**WEST SUSSEX COUNTY COUNCIL
STRATEGIC PLANNING CONSULTATION**

SUBJECT: A/106/13/PD - Conversion of office building in B1A use to three dwellings C3 use at Avenals Farm.

Avenals Farm, Water Lane, Angmering, West Sussex, BN16 4EP

Dwg No: **1733.1/01** Date: **JULY 2013** Drawn: **PS**

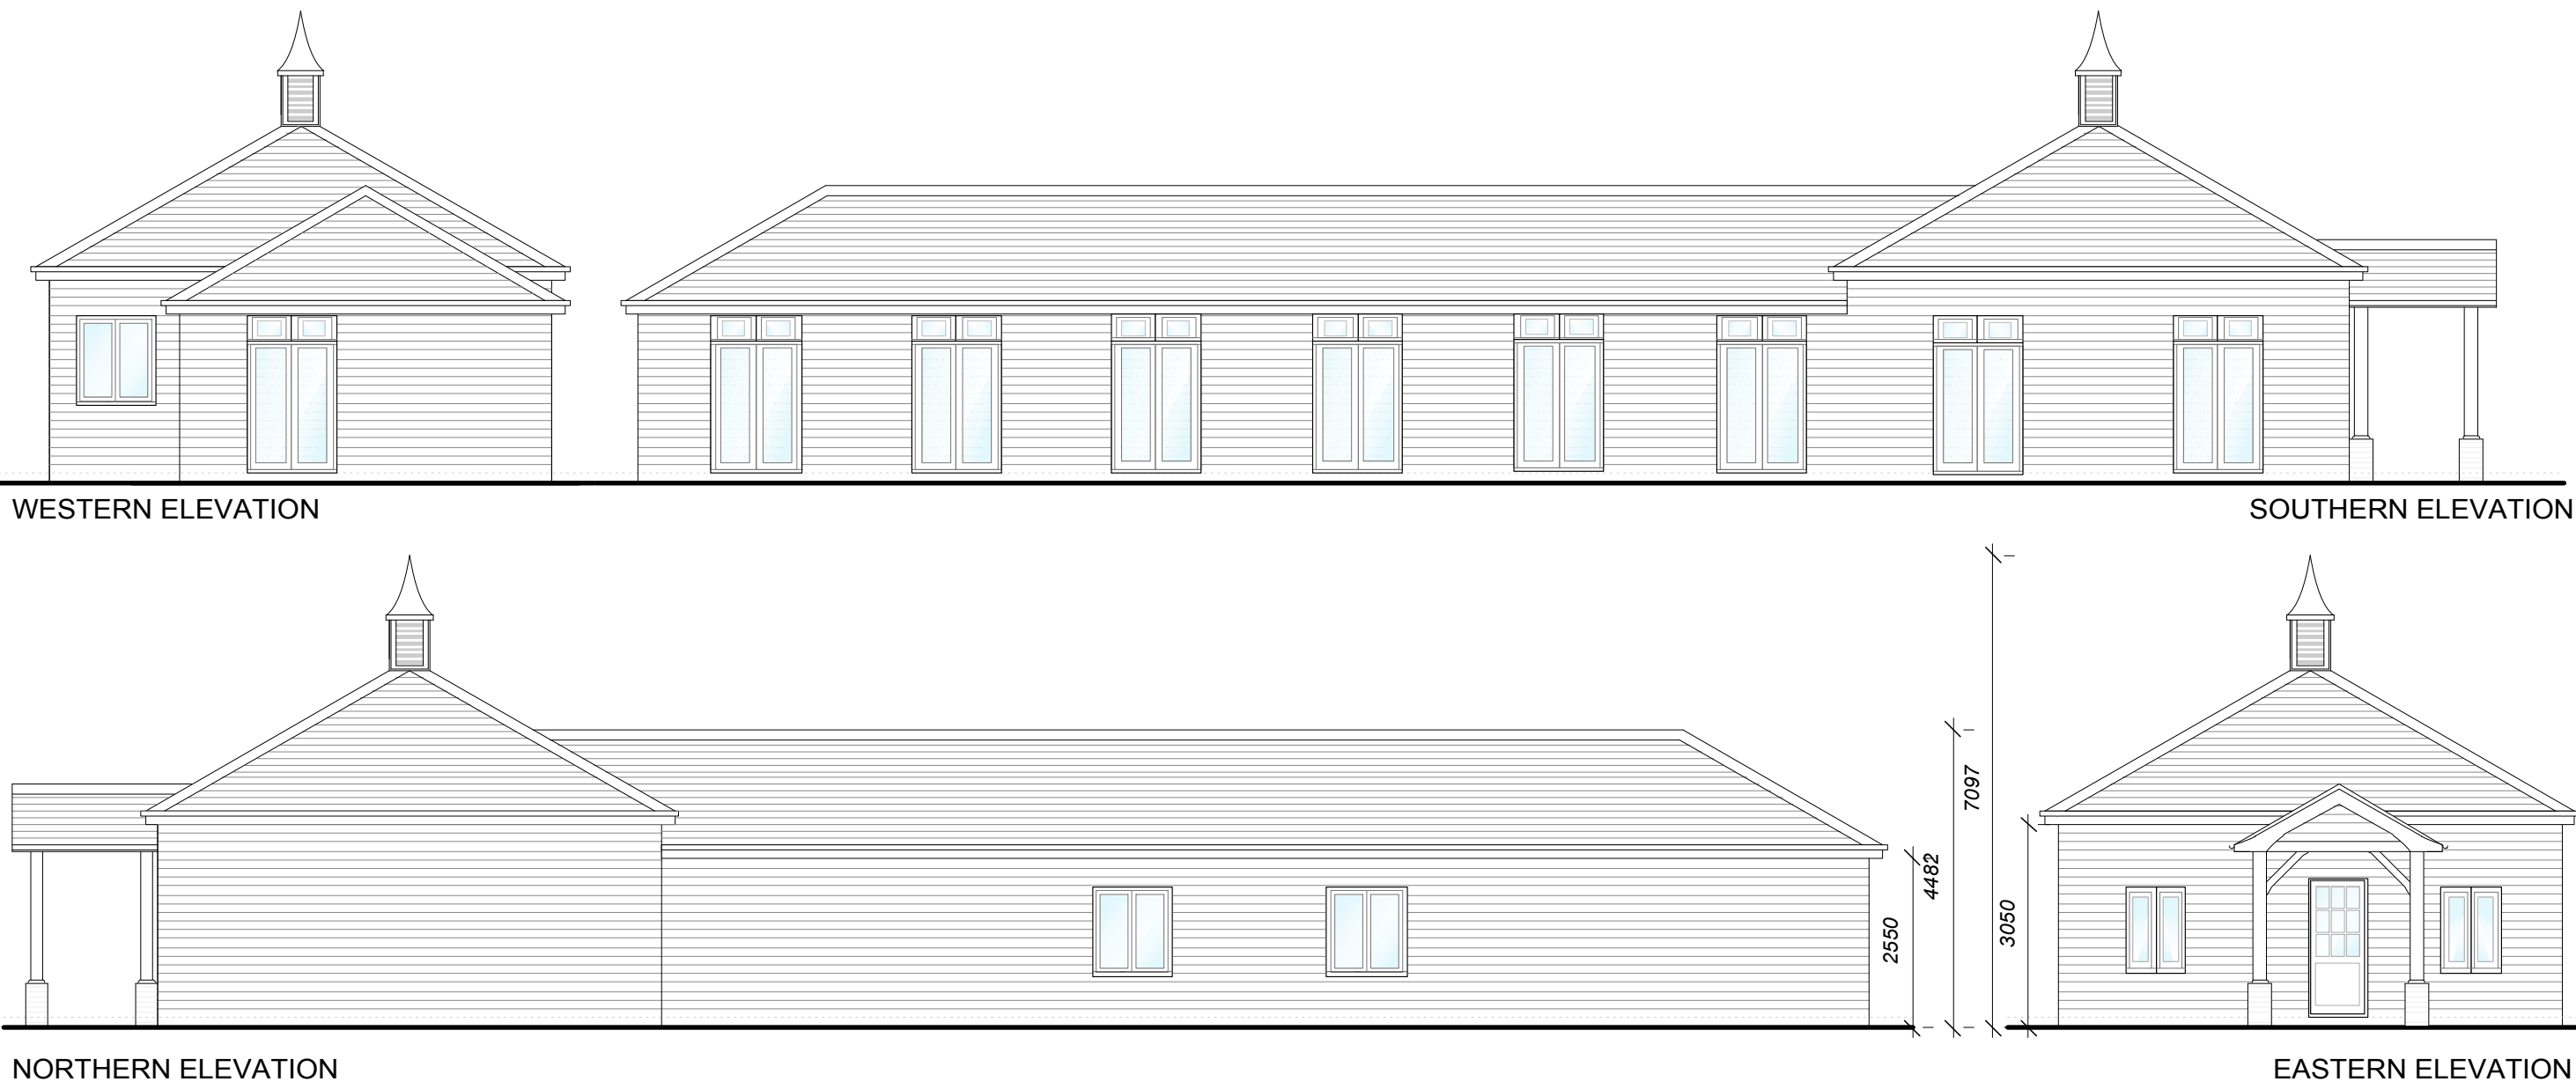
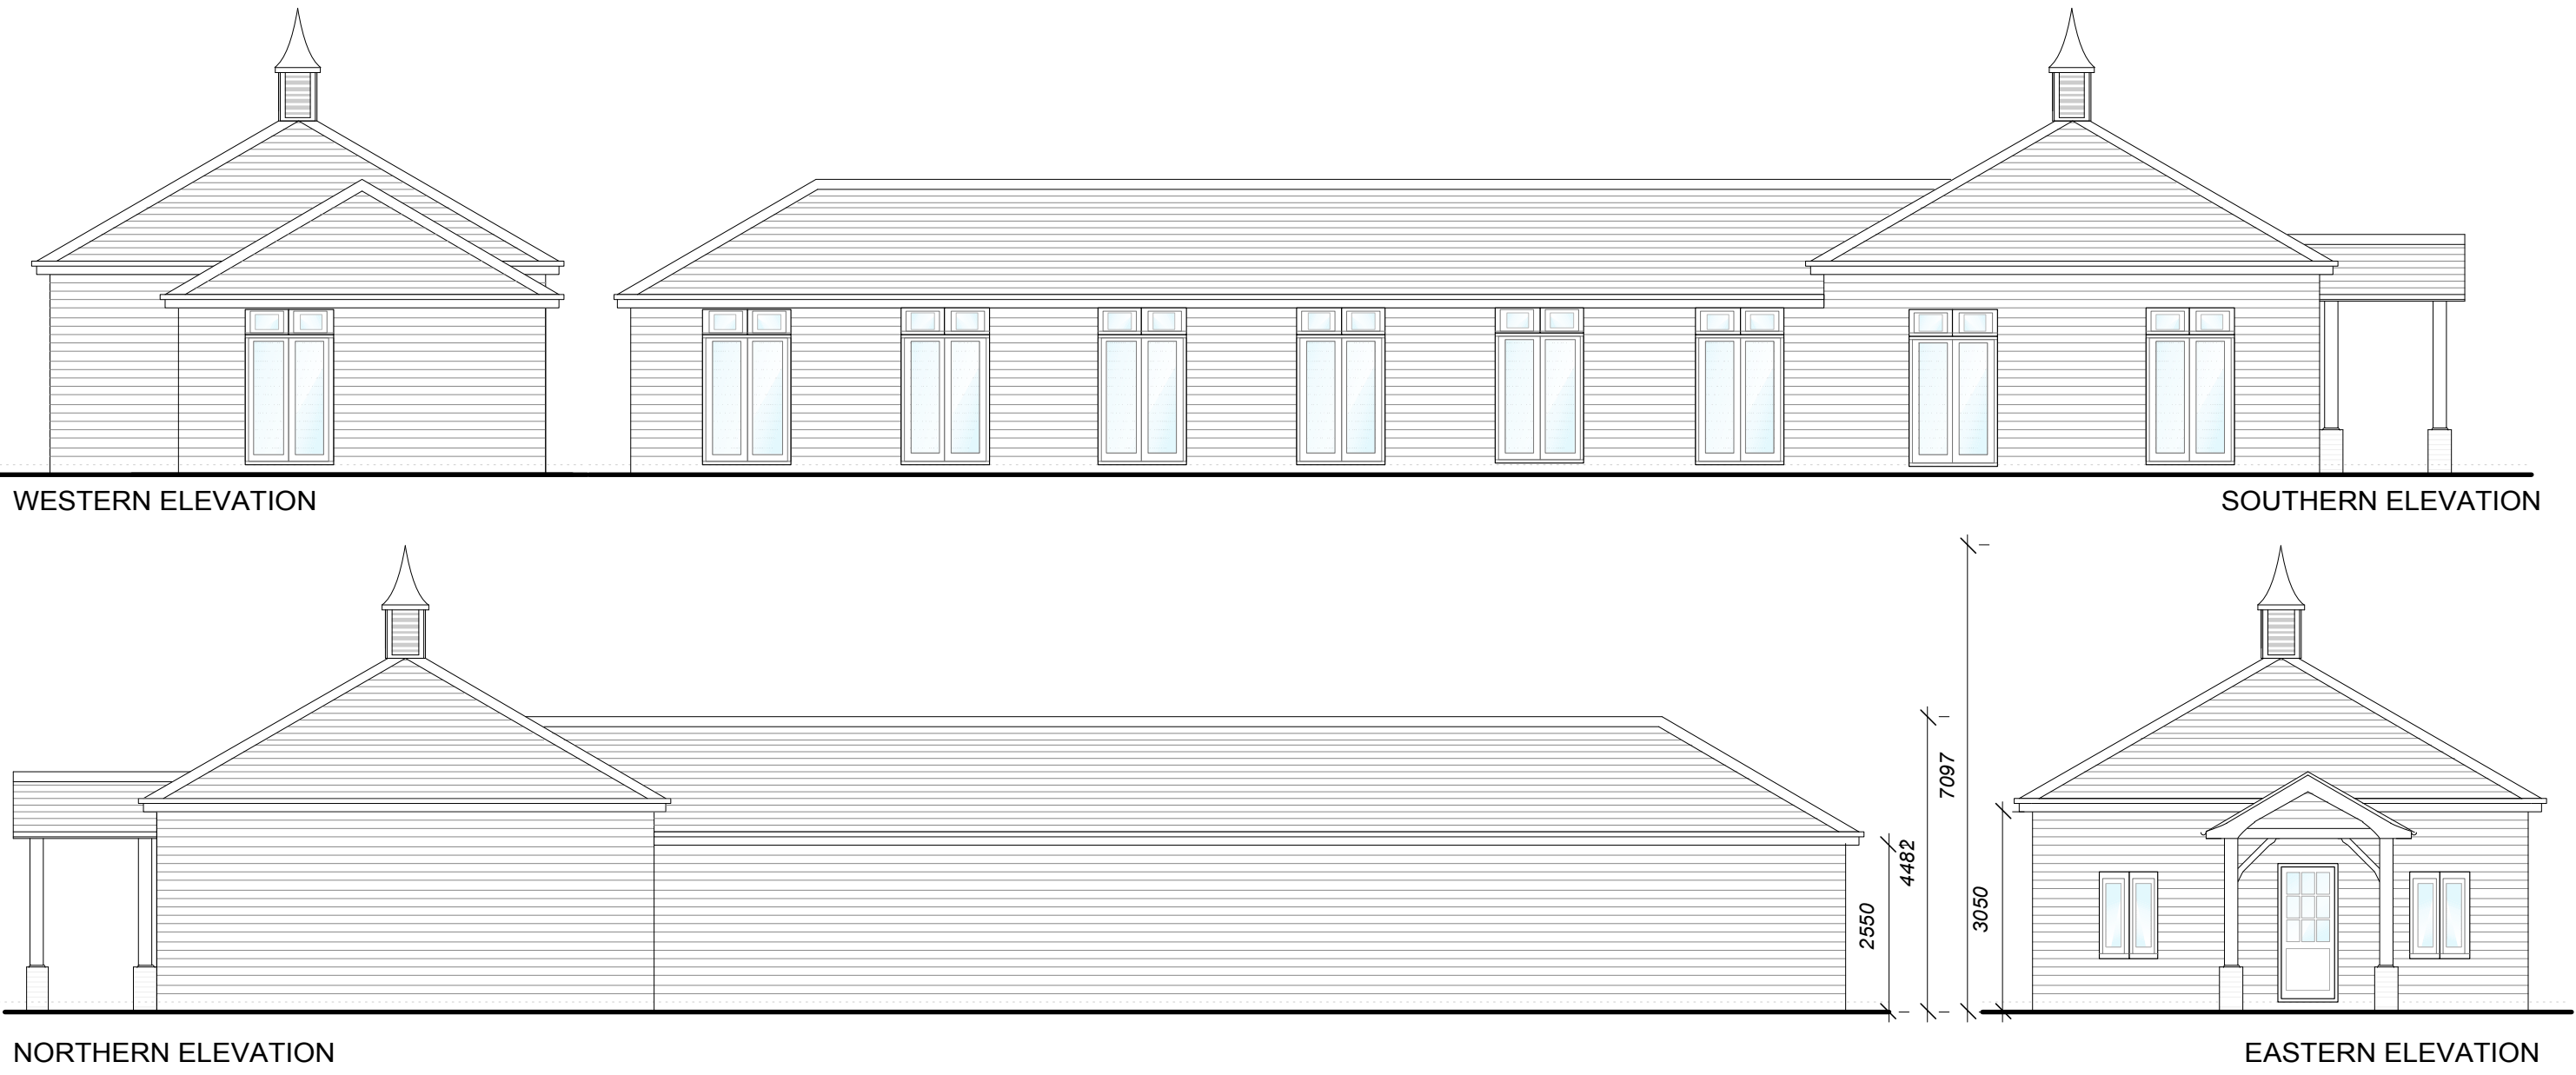
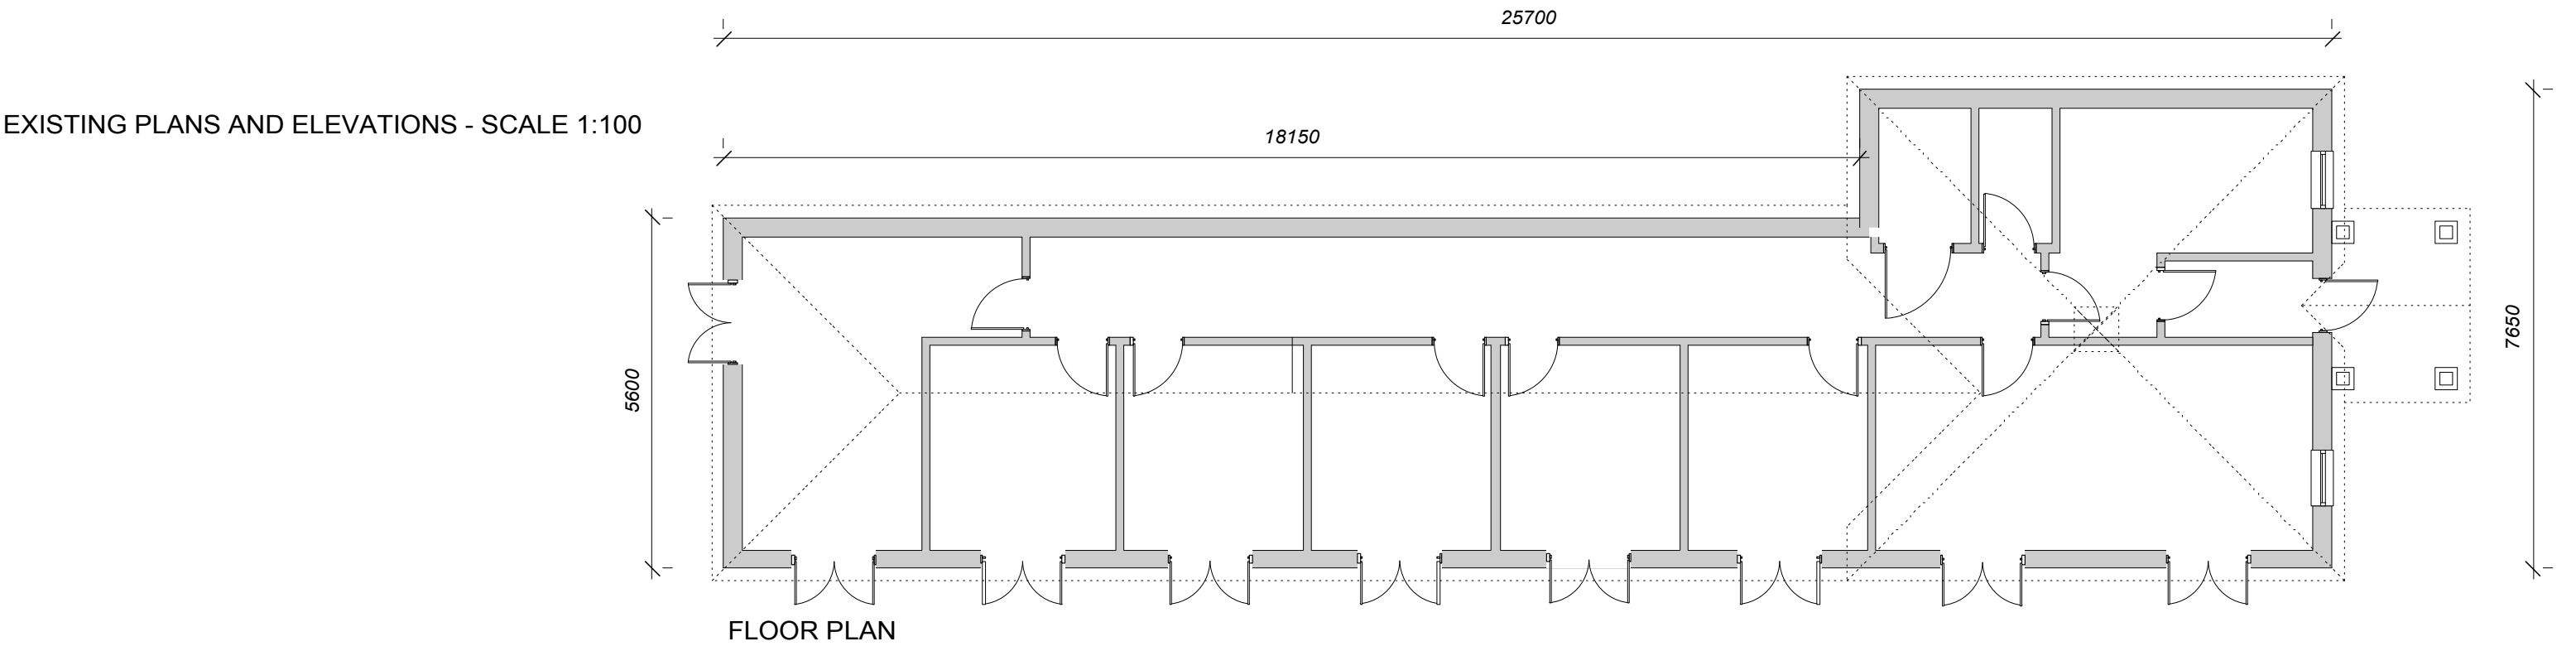
From inspection of the plans and information provided, it is proposed to utilise an existing access that currently serves the site from Water Lane (a class C road with a speed limit of 30mph within the site access vicinity). There is also two give way speed control measures to the east and west of the access, ensuring the speeds in this area are kept to a minimum.

It is envisaged the change in use of the building from a B2 use to a C3 use will result in a significant less intensity of traffic and vehicular movements on the access. Therefore the access and visibility available in both directions is deemed to be adequate to support this development.

A provision of 6 car parking spaces will be available for the future residents of the dwellings and going by the size of each unit within this area, would meet the highway requirements. A turning area on site is also provided, allowing vehicles to exit on to the highway in the forward gear.

There would be no concerns raised with this application from a highway safety perspective.
